CITY OF ALBUQUERQUE

October 17, 2024

Re: Starbucks/ 2004 Wyoming Blvd. NE
1825 Edith Blvd. NE
60-Day Temporary Certificate of Occupancy
Transportation Development Final Inspection
Engineer's Stamp dated 02-26-24 (H20-D003E)
Certification dated 02-26-24

CURB RAMP IMPROVEMENTS
GRADING DETAIL

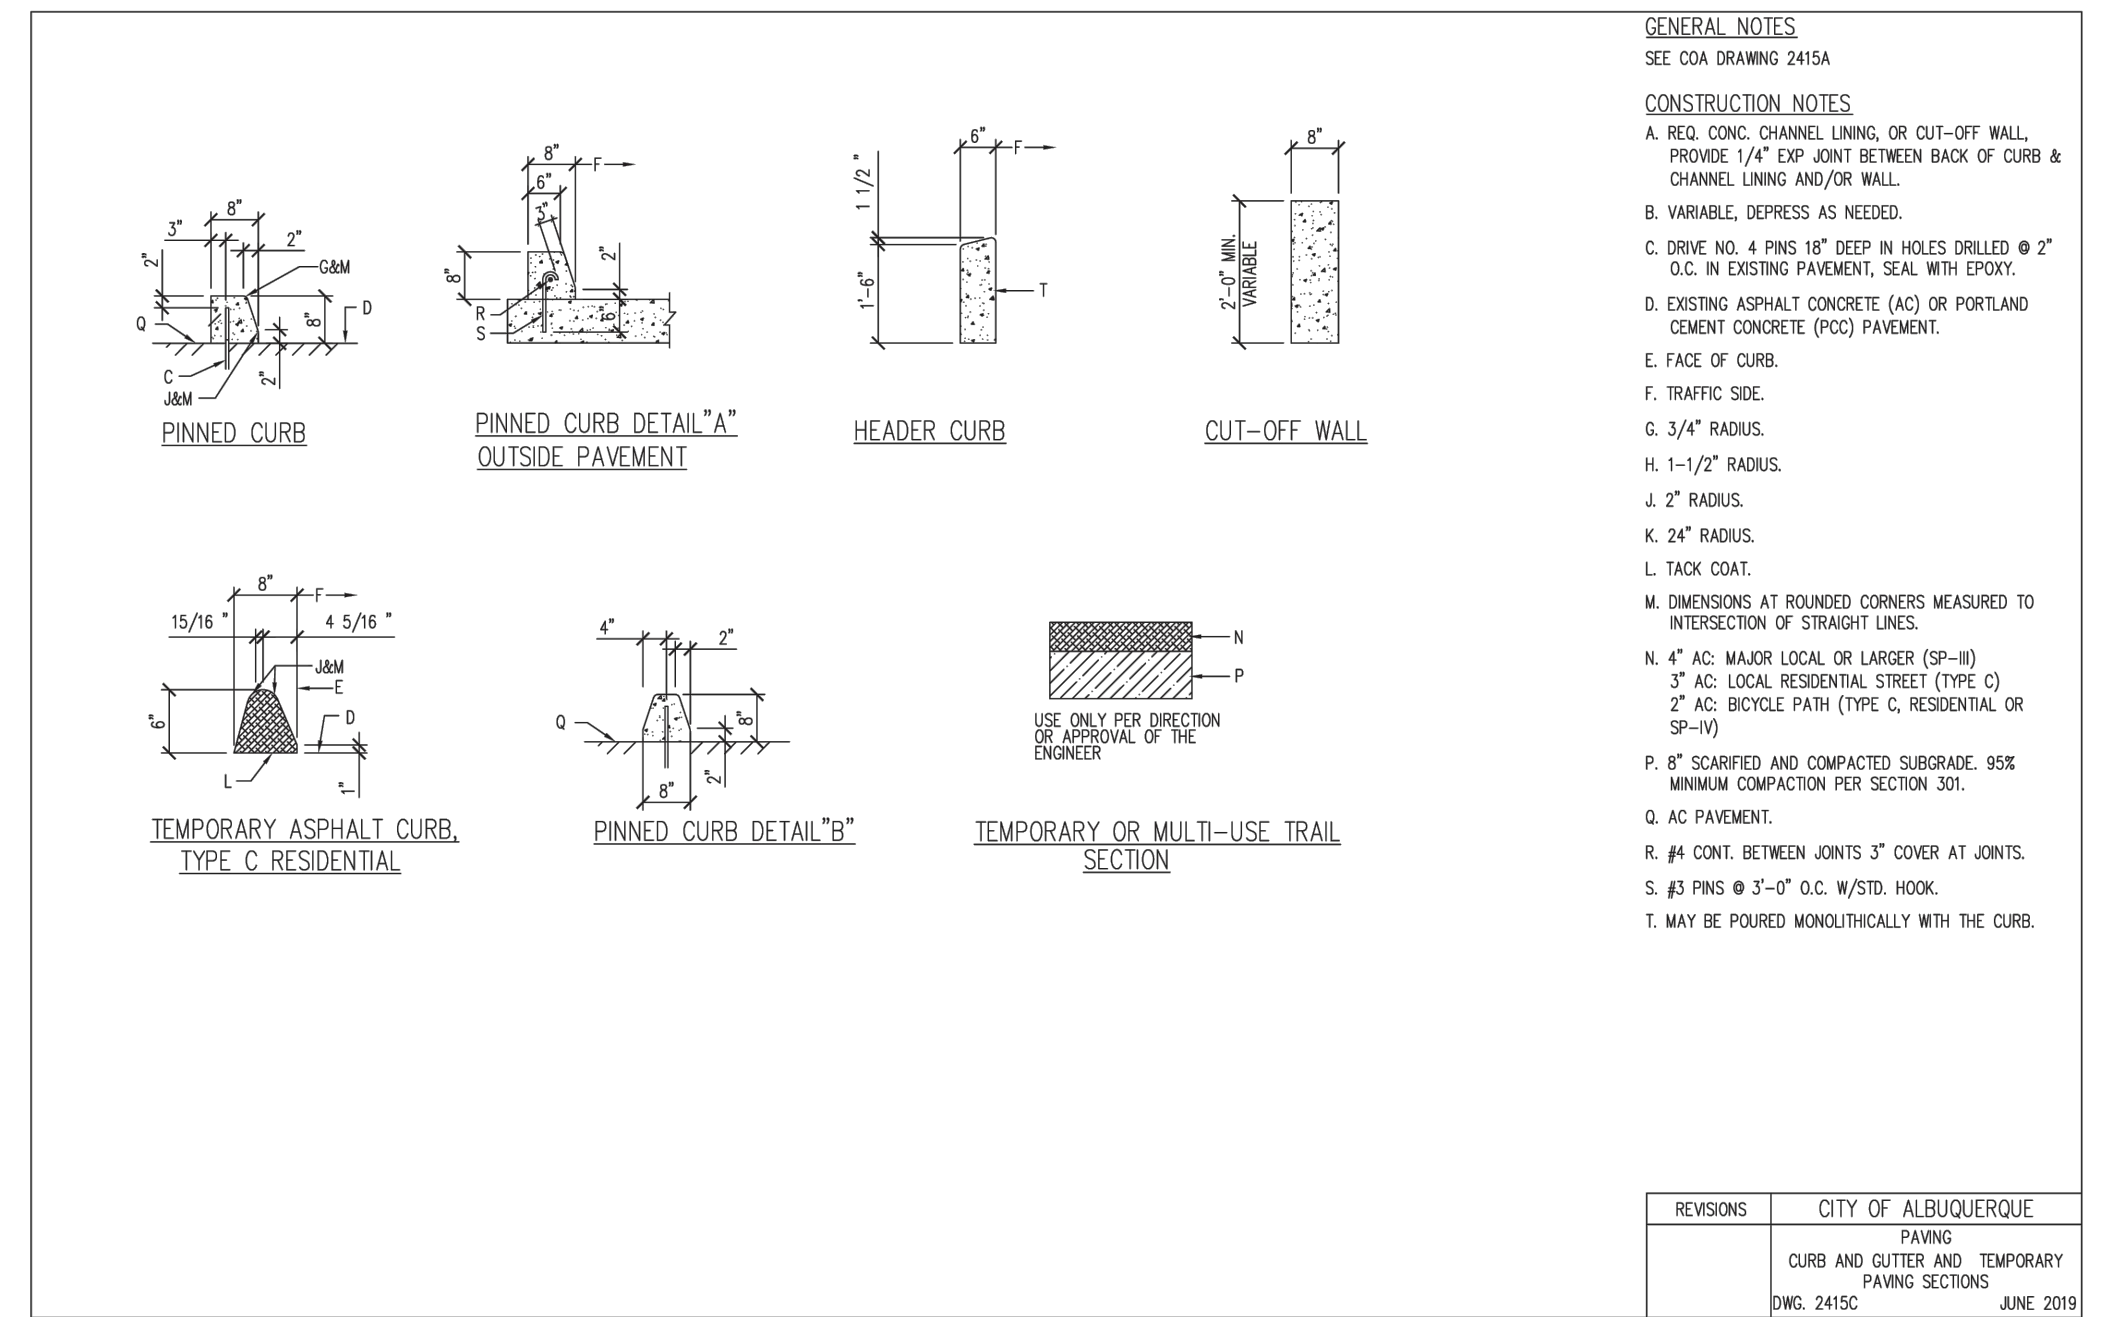
- Provide "MC" pavement marking for the Motorcycle parking spaces.
- Anchor down Bike Racks.
- The corner ramp at the corner of Wyoming blvd and Northeastern Blvd.: This ramp must be updated to the current ADA standard and has truncated domes installed. The running slope for this existing ramp is ranged between 12% and 9.9%, while the running slope for the ADA ramp should not exceed 8.3% per city standard. Also, due to the existing Traffic box, please contact the Traffic engineering department/ Traffic signal section.
